Please upload the below and attached to the above application: Further information (Drainage)

Condition 5- surface water drainage

Condition 6- discharge of flows to watercourse

Subject: RE: BR/188/20/DOC

Rate	July 20	Scale	1/200	Org. No.
own	EG	Chk'd	QA'D	424861-101P

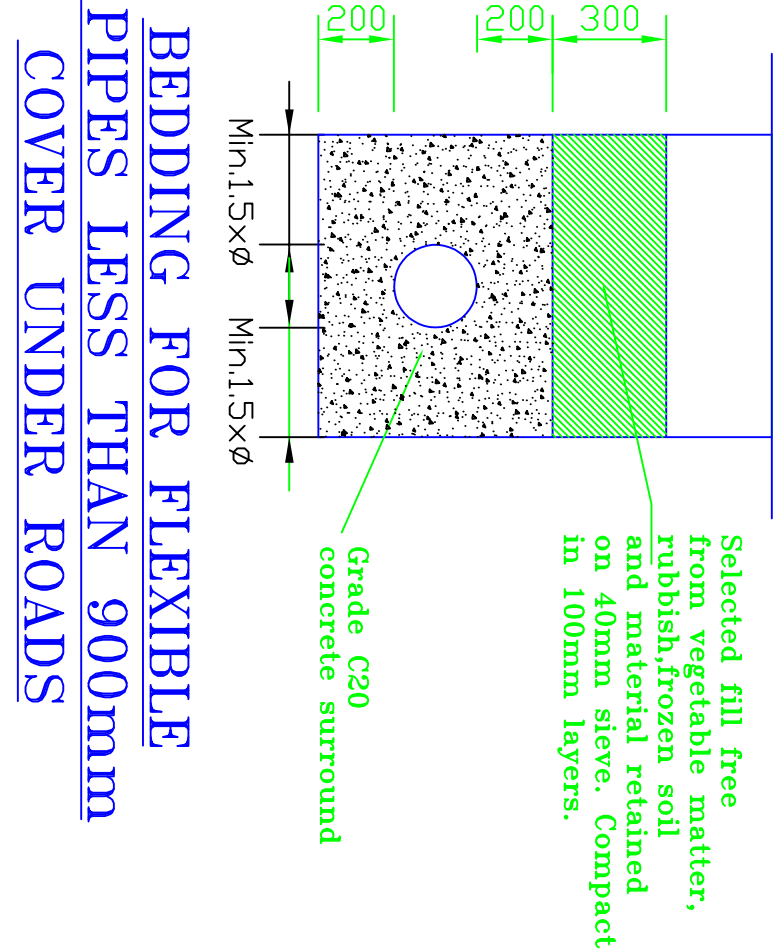
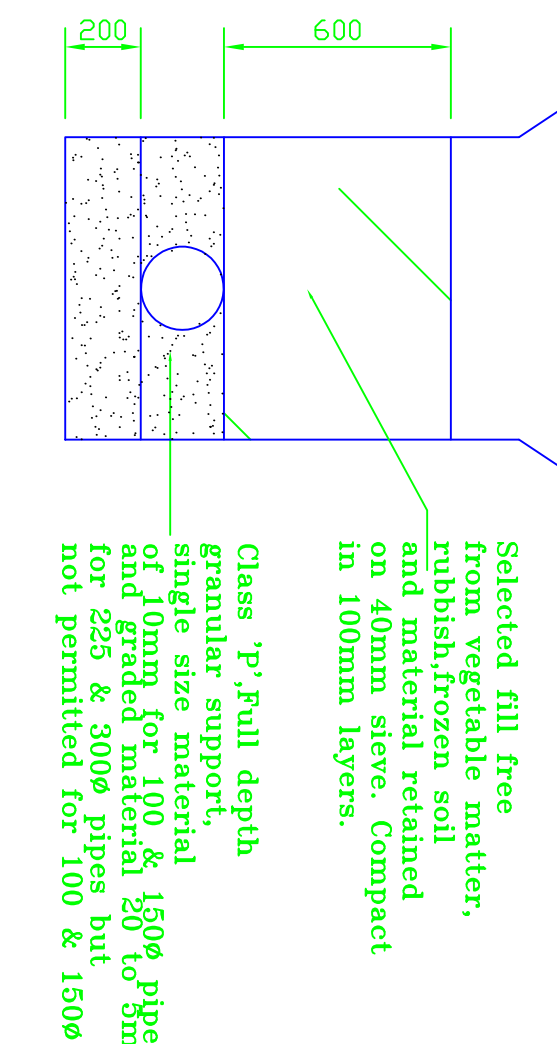
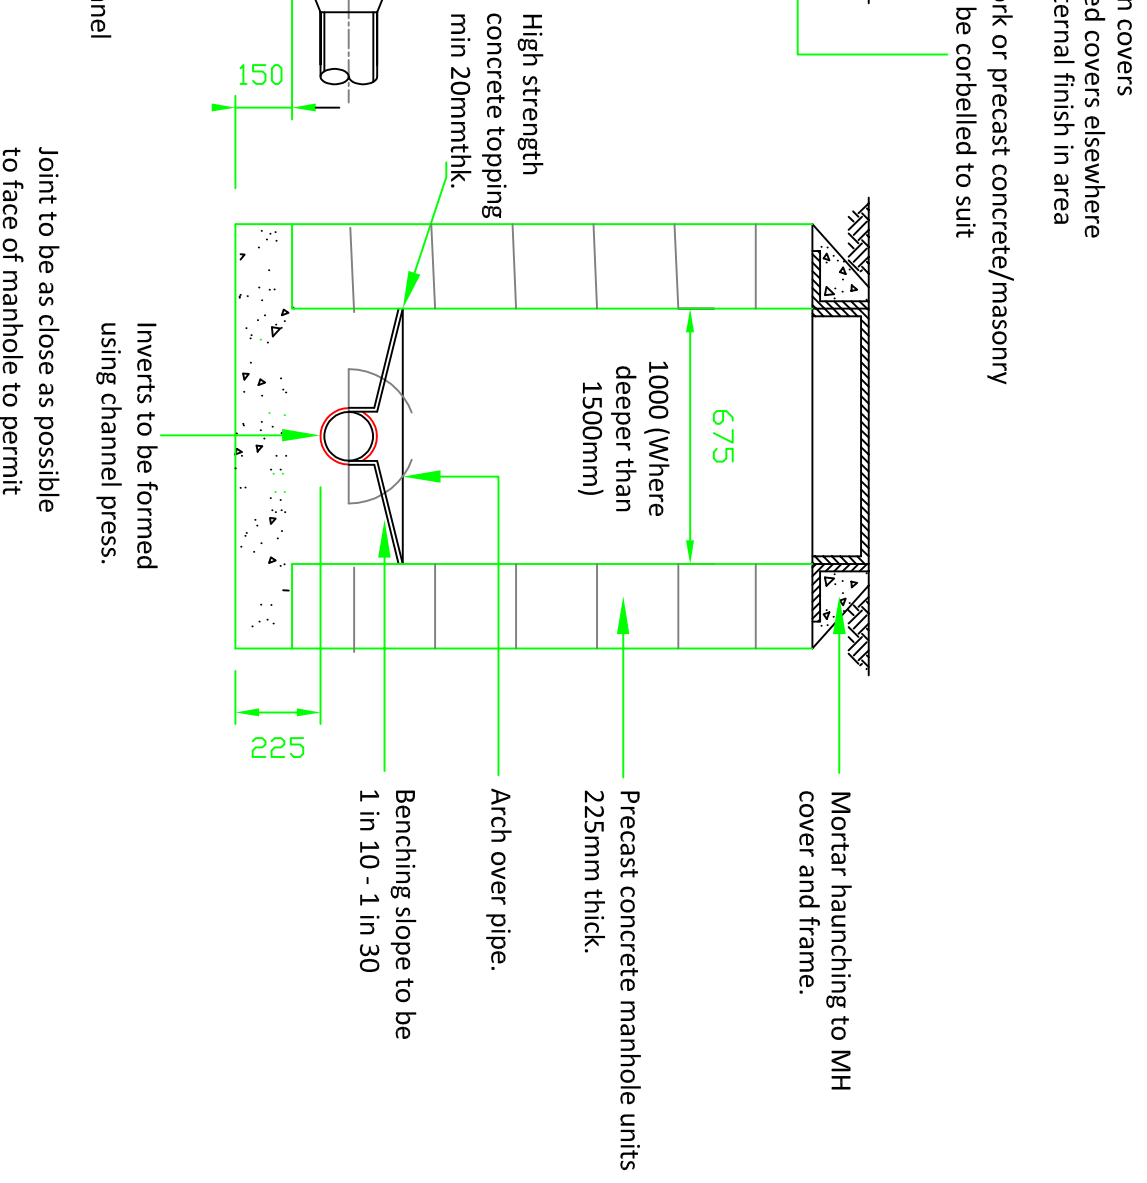
We also note that finish and formation levels must be shown on permeable paving and it must be accurately modelled to include any slope.

These are shown on the sectional drawings on the drainage details drawing and as noted above.

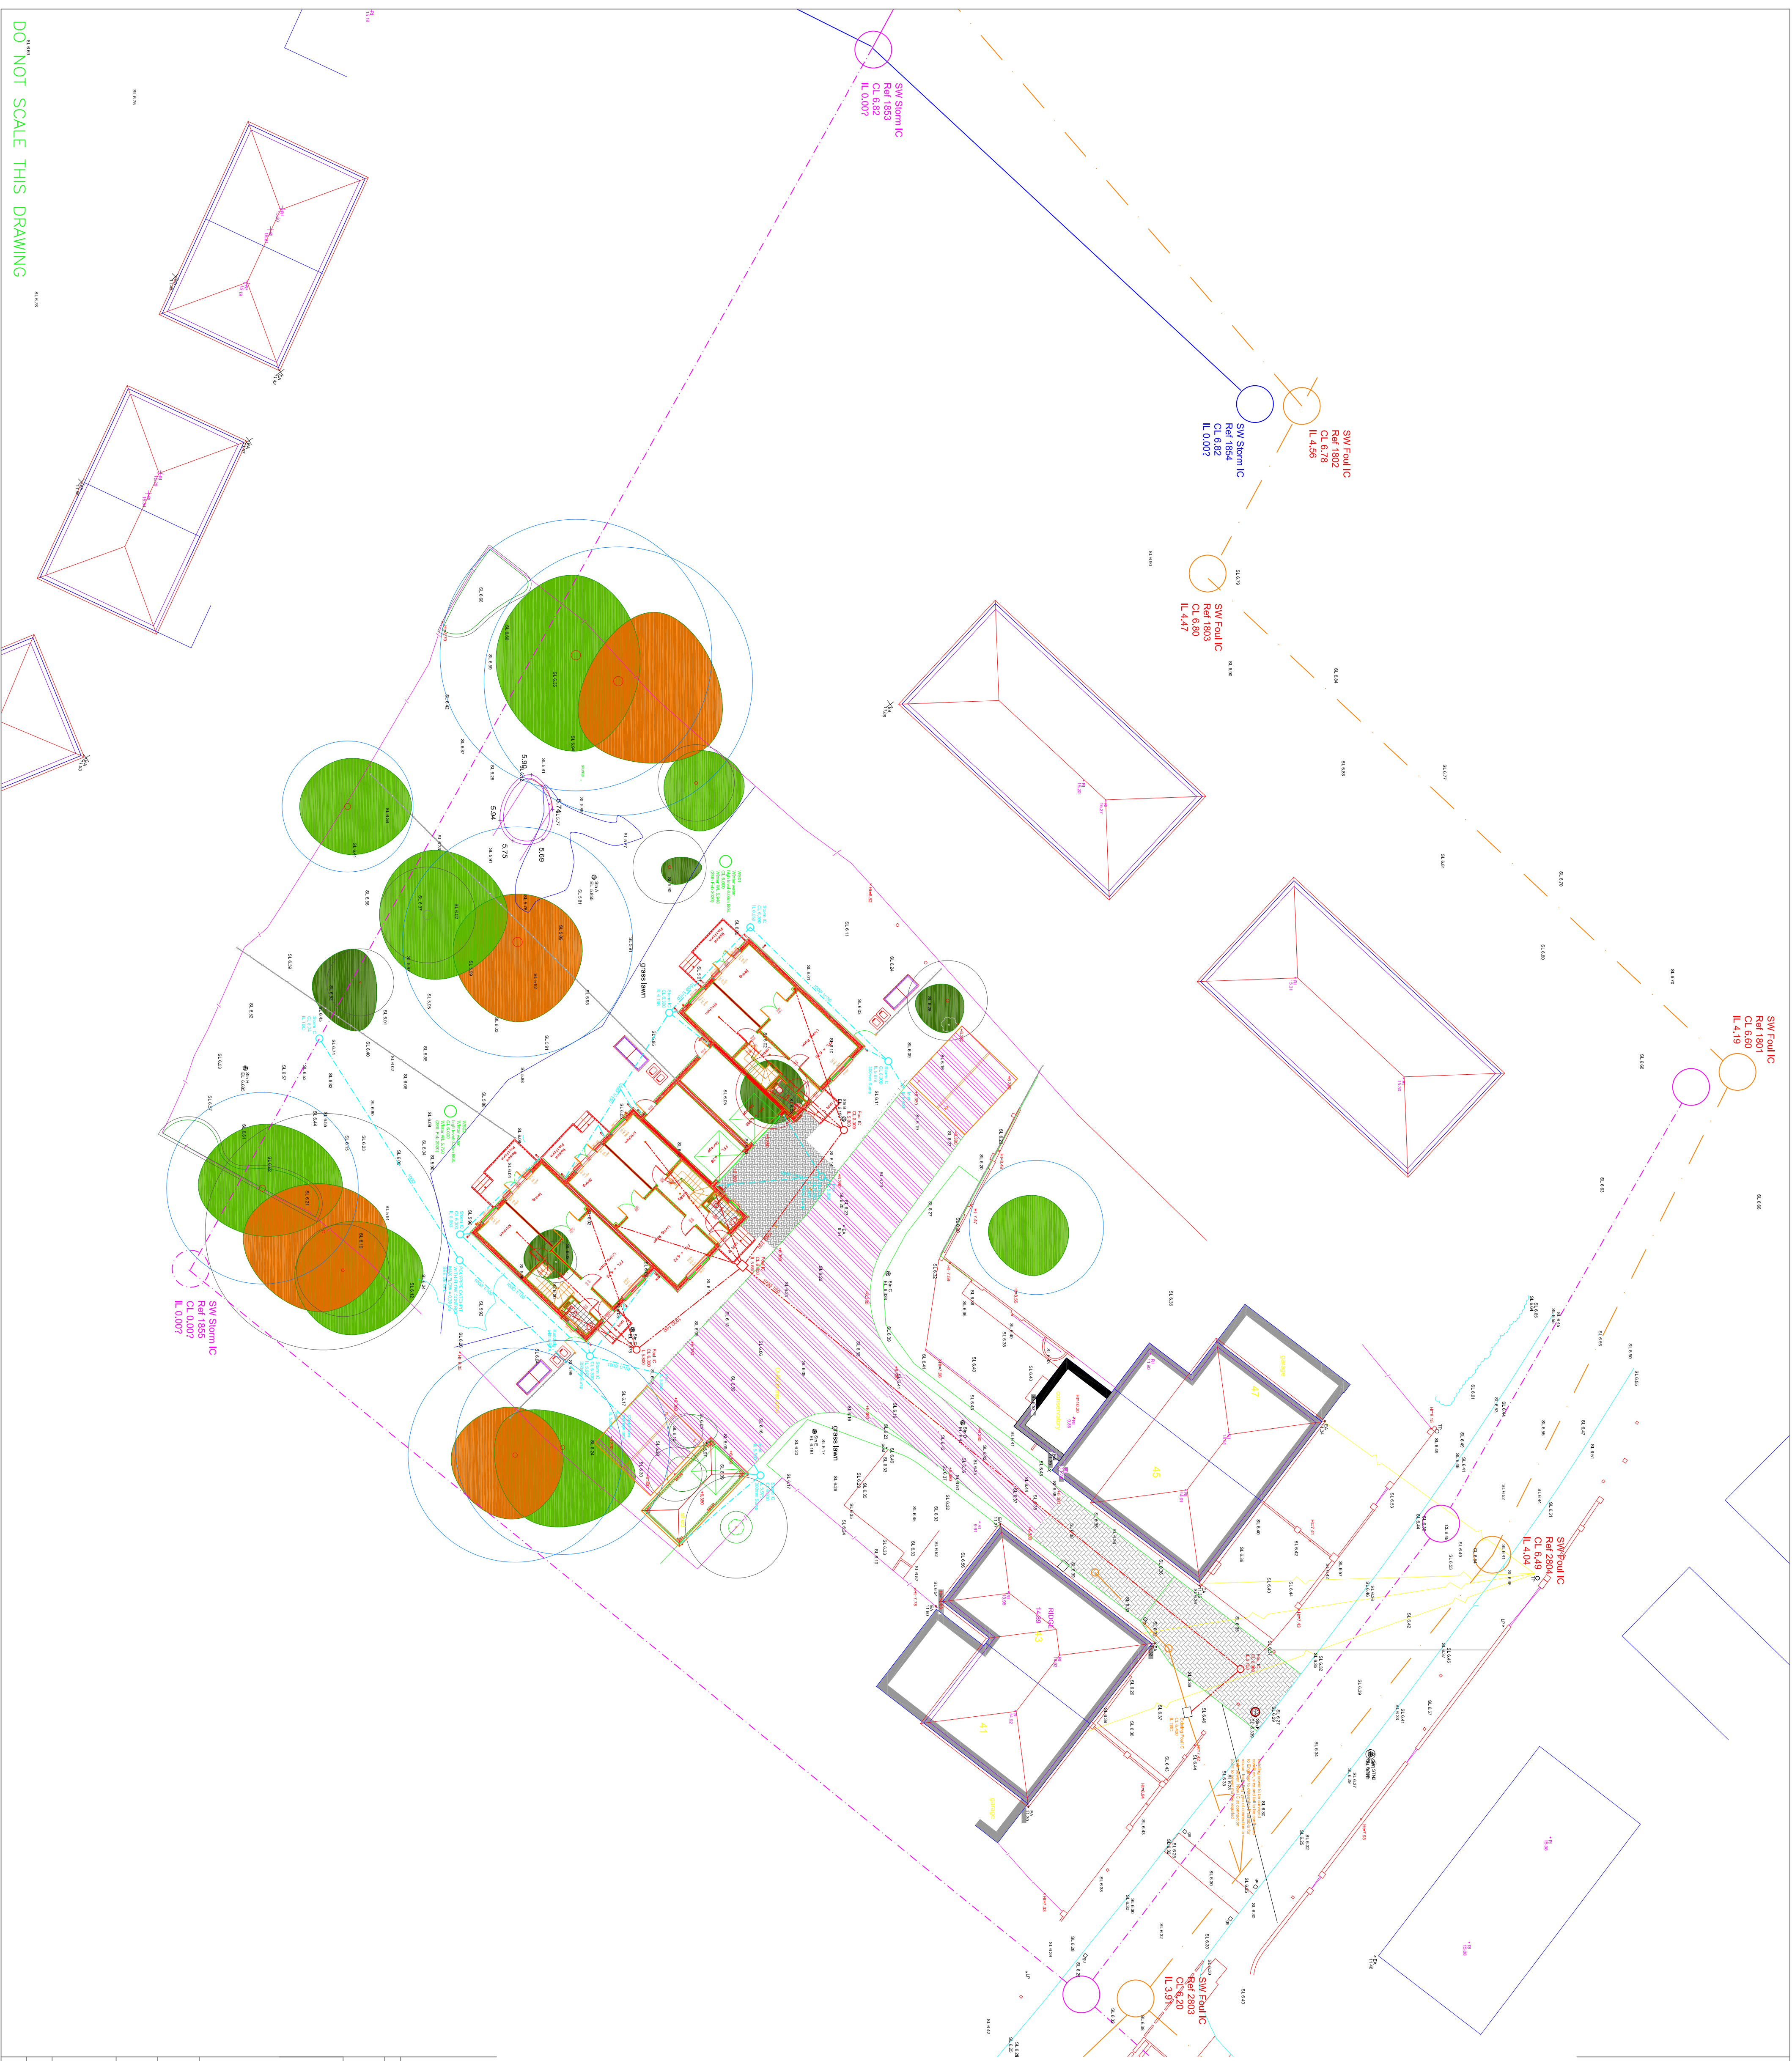
The documents submitted do not accord with the documents submitted to support the planning appeal. Details supplied to discharge this condition must tie in with this, specifically regarding levels and extent of permeable paving to ensure that flood risk is not increased elsewhere.

Whether the sub-base of the permeable paving is lined or not is dependent upon winter groundwater monitoring. Disappointingly this monitoring was only completed to the south west of the proposed dwellings and not in the area proposed for permeable paving. Given the differences in elevation and sensitivity of the site it is not appropriate to use these results to the north east of the proposed buildings. Therefore it is not possible to determine if the base needs to be lined and if attenuated discharge to watercourse is required.

We have updated the calculations as noted below and increased the area of permeable paving and flood storage to allow for the required 35m³ of flood water storage loss caused on the site by the new development (from the original Robert Clark Asso report/calcs). We have also now proposed a tanked system (and not an infiltration system) as the project developer would like to progress, this revised proposal makes the groundwater testing

The winter ground water monitoring was carried out in February 2020, which was one of the wettest February's ever recorded. Therefore we believe that the ground water levels are accurate and relevant for the design. The ground level in the area of the monitoring was 6.000m AOD, the highest ground water level recorded was 5.940m AOD. Therefore this is considered the highest ground water level expected on site. Therefore we have revised our proposals to a tanked system, proposed details and levels are given on the drawings attached. We have proposed to install an overflow to the culvert as originally proposed. This overflow pipe would only need to discharge at a rate of 0.391 L/s to have the same effect as the soakaway test results, therefore the flow to the culvert would not be excessive if a tanked storage solution is insisted upon by the planners / drainage consultee. We have added this to the drawing as a belt and braces approach to allow the project to progress.
